V1_Site Development Plan_COMMENTS.pdf Markup Summary

PROJECT INFORMATION:
 PCD NO: PPR2610
 TAX SCHEDULE NO: 550000164
 PROPERTY ADDRESS: 6155 FOUNTAIN VALLEY SCHOOL ROAD
 CURRENT ZONING: A-5, CAD-O(ANAV)
 PROPOSED ZONING: A-5
 PROPOSED LAND USE: PRIVATE EDUCATIONAL INSTITUTION
 PROPOSED BUILDING(S) USE: ACADEMIC
 PROPERTY AREA: 9.37 AC

FOUNTAIN VALLEY SCHOOL
 ACADEMIC CENTER

SITE DEVELOPMENT PLAN

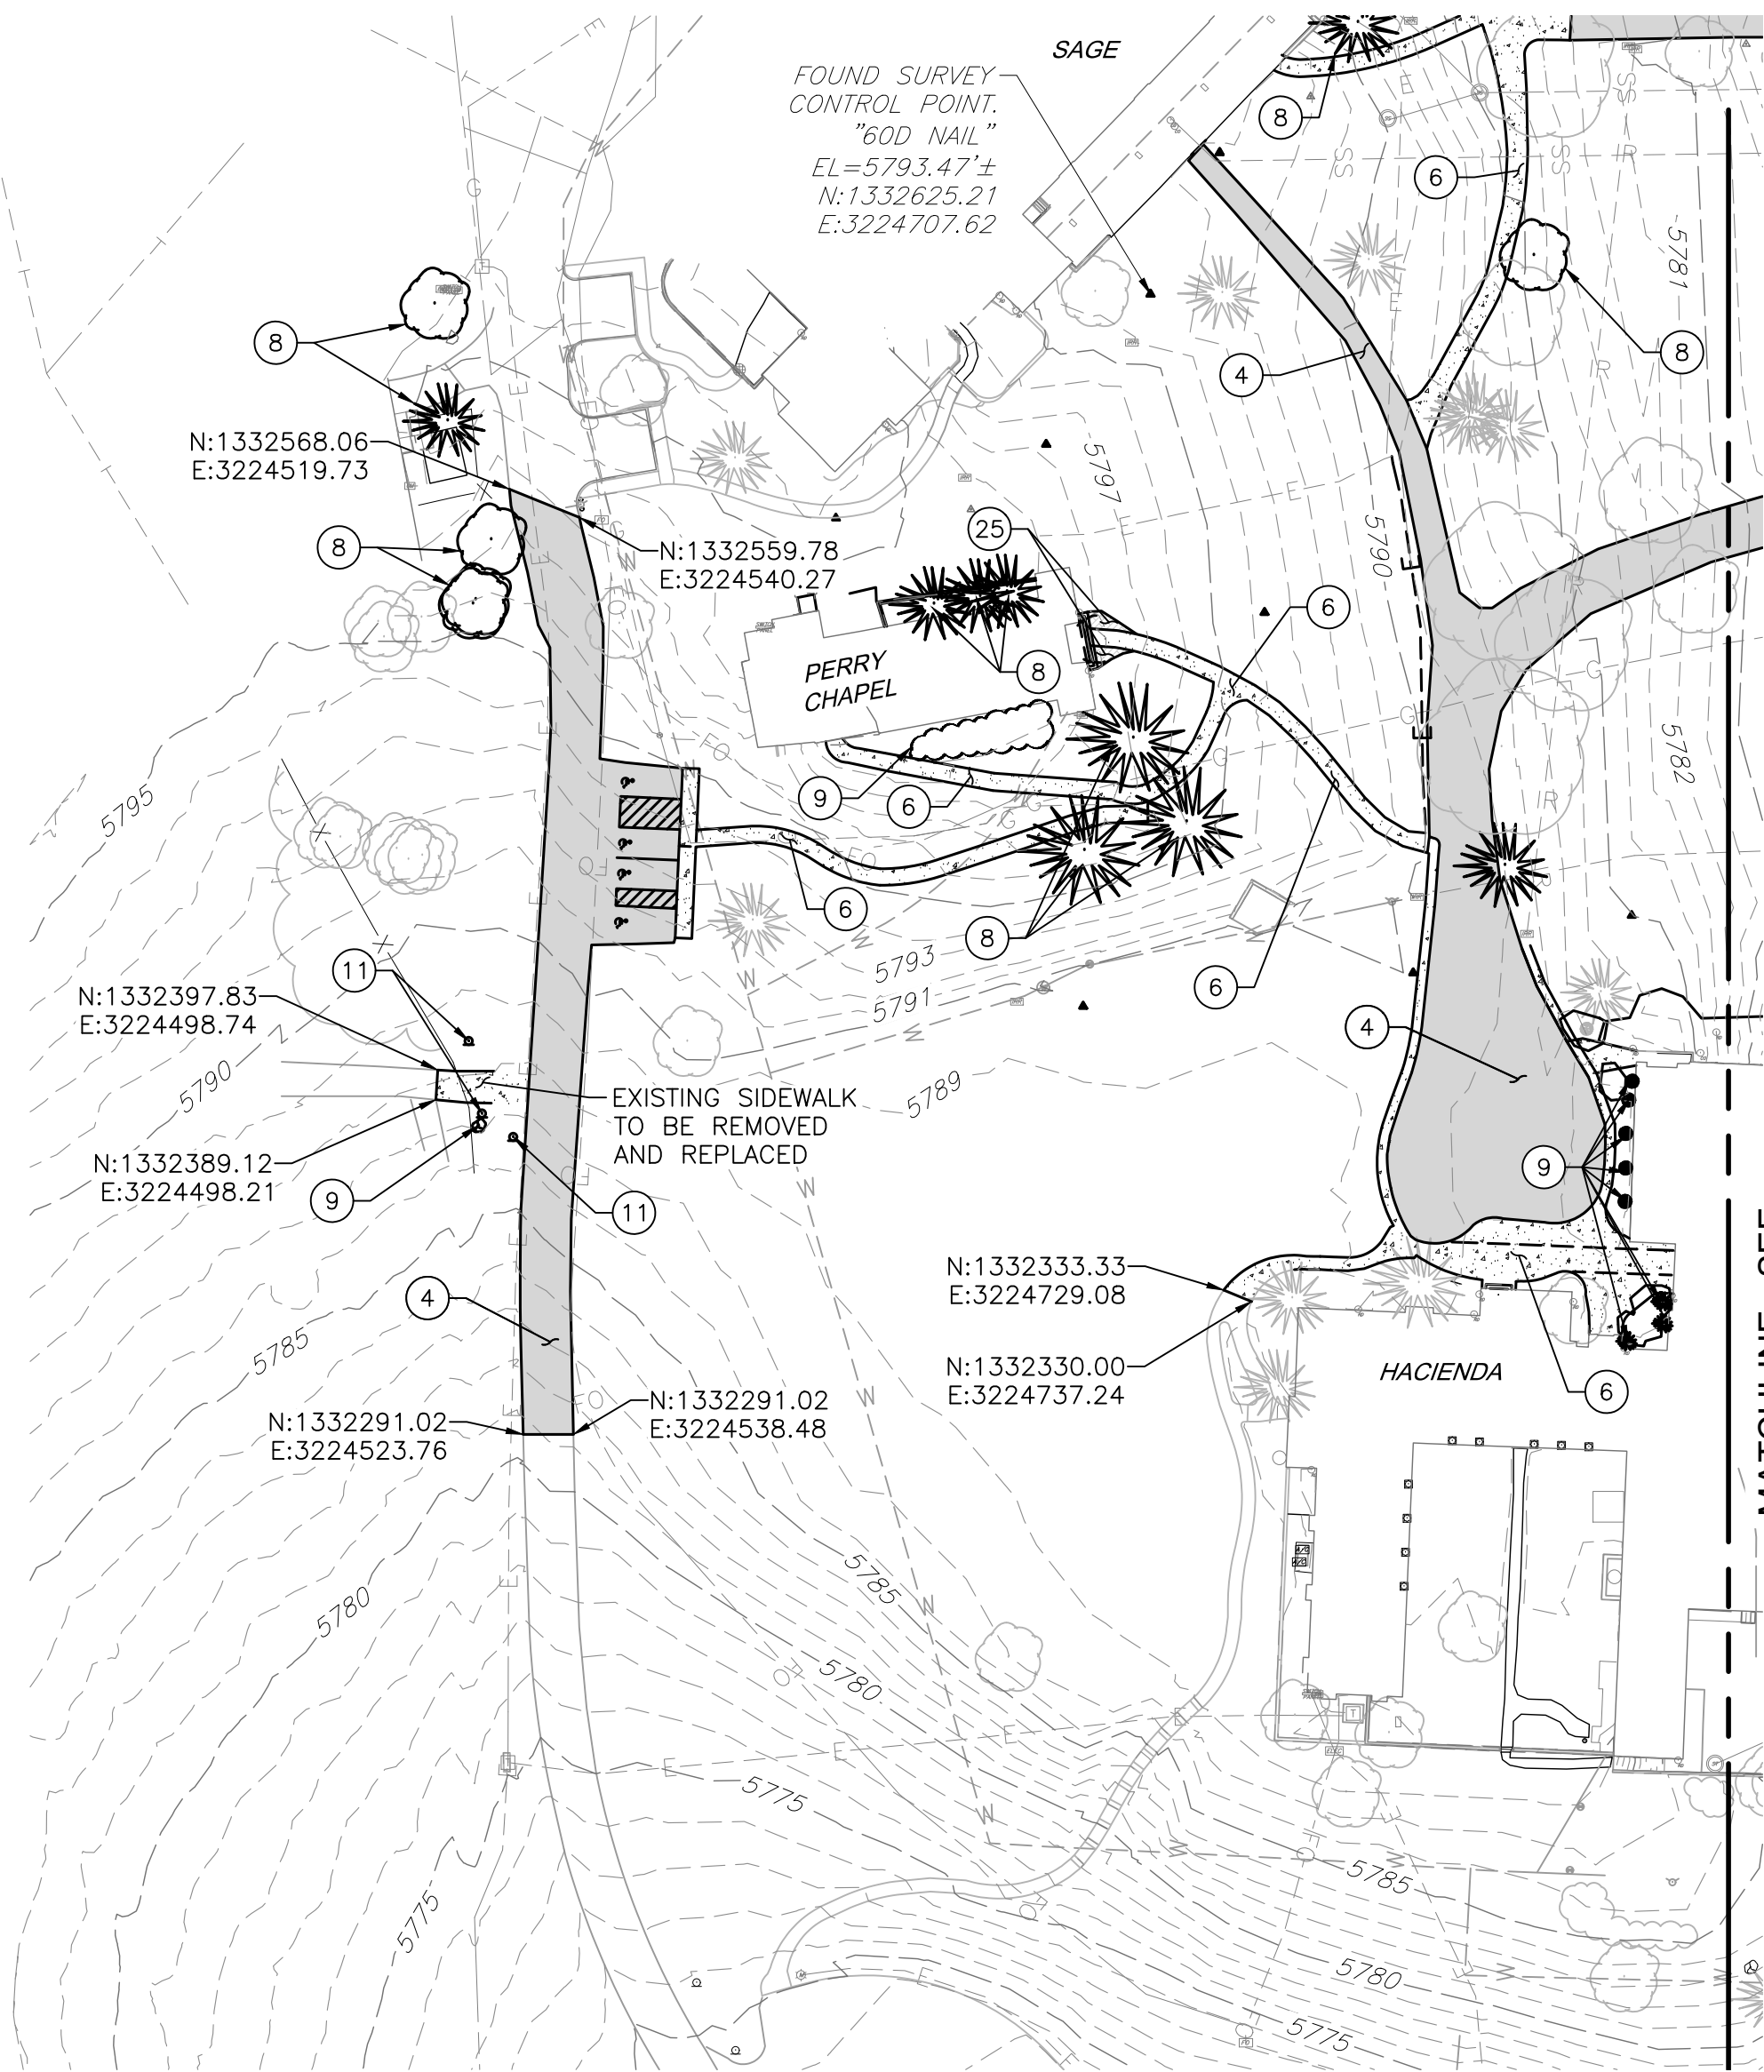
Provide a sheet showing the demo plan and what buildings are being removed. Include GSF of each building being demo'd
